CORRECTIONS NEEDED
Re-Submit Plans For Approval

NIEDERMAN RESIDENCE
REMODEL / ADDITION
6800 96TH AVE SE
MERCER ISLAND, WA 98040

From: Jeromy Hicks <jeromy.hicks@mercergov.org>
Date: Tuesday, November 19, 2019 at 1:07 PM
To: Suzanne Zahr <sz@suzannezahr.com>, Chris Niederman <Chris@niederman.com>
Cc: Nicole Niederman <Nicole@niederman.com>
Subject: RE: Niederman Residence: 6800 96th Ave SE - Fire Code Reqs

From: Suzanne Zahr <sz@suzannezahr.com>
Sent: Tuesday, November 19, 2019 1:03 PM
To: Chris Niederman <Chris@niederman.com>
Cc: Nicole Niederman <Nicole@niederman.com>; Jeromy Hicks <jeromy.hicks@mercergov.org>
Subject: Niederman Residence: 6800 96th Ave SE - Fire Code Reqs

DRIVEWAY ELEVATION VIEW
SCALE 1/8" = 1'-0"

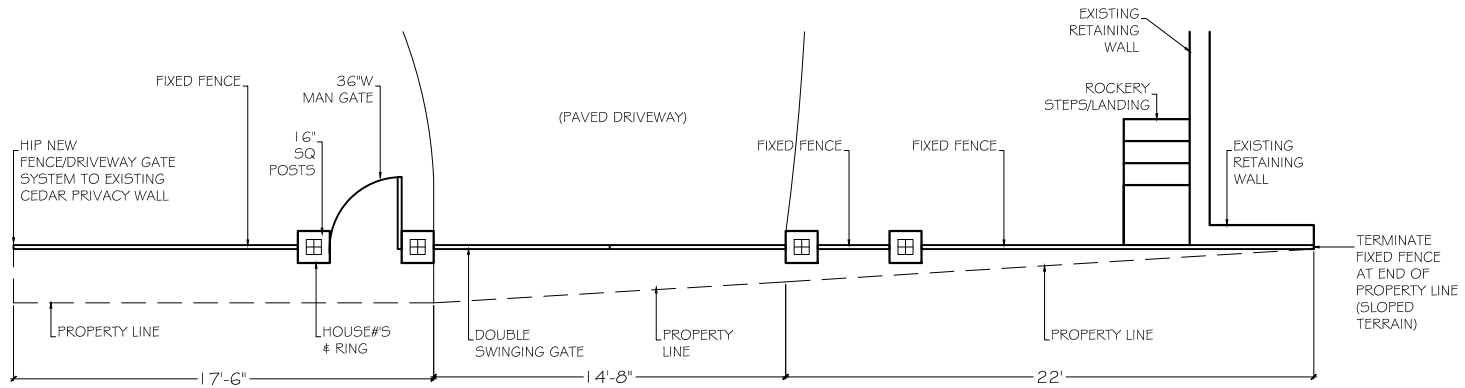
- Considering the approx. width of the access road at 14', Jeromy suggests that the gate meet that width, though code requires a 20' opening. Considering the existing site access conditions, no less than a 12' gate opening would be acceptable. This allows small emergency vehicles 'minis' to negotiate the access road and reach your home. (14' sounded to me like a reasonable compromise)

- You are not on an arterial road, so you're not obligated to comply with the 30' clearance outside of your gate.
- You are required to install a 'click-to-enter' (more expensive, but nicely automated) or Knox box system (more affordable, but less able to integrate with smart technology) on your Entry Gate. This allows emergency vehicles to open your gate, in case of emergency.

This looks great! Thank you for summarizing our conversation. Please let me know if you have any further questions moving forward. The gate will require a permit... We can over the counter the permit with the appropriate information included in the developer manual.
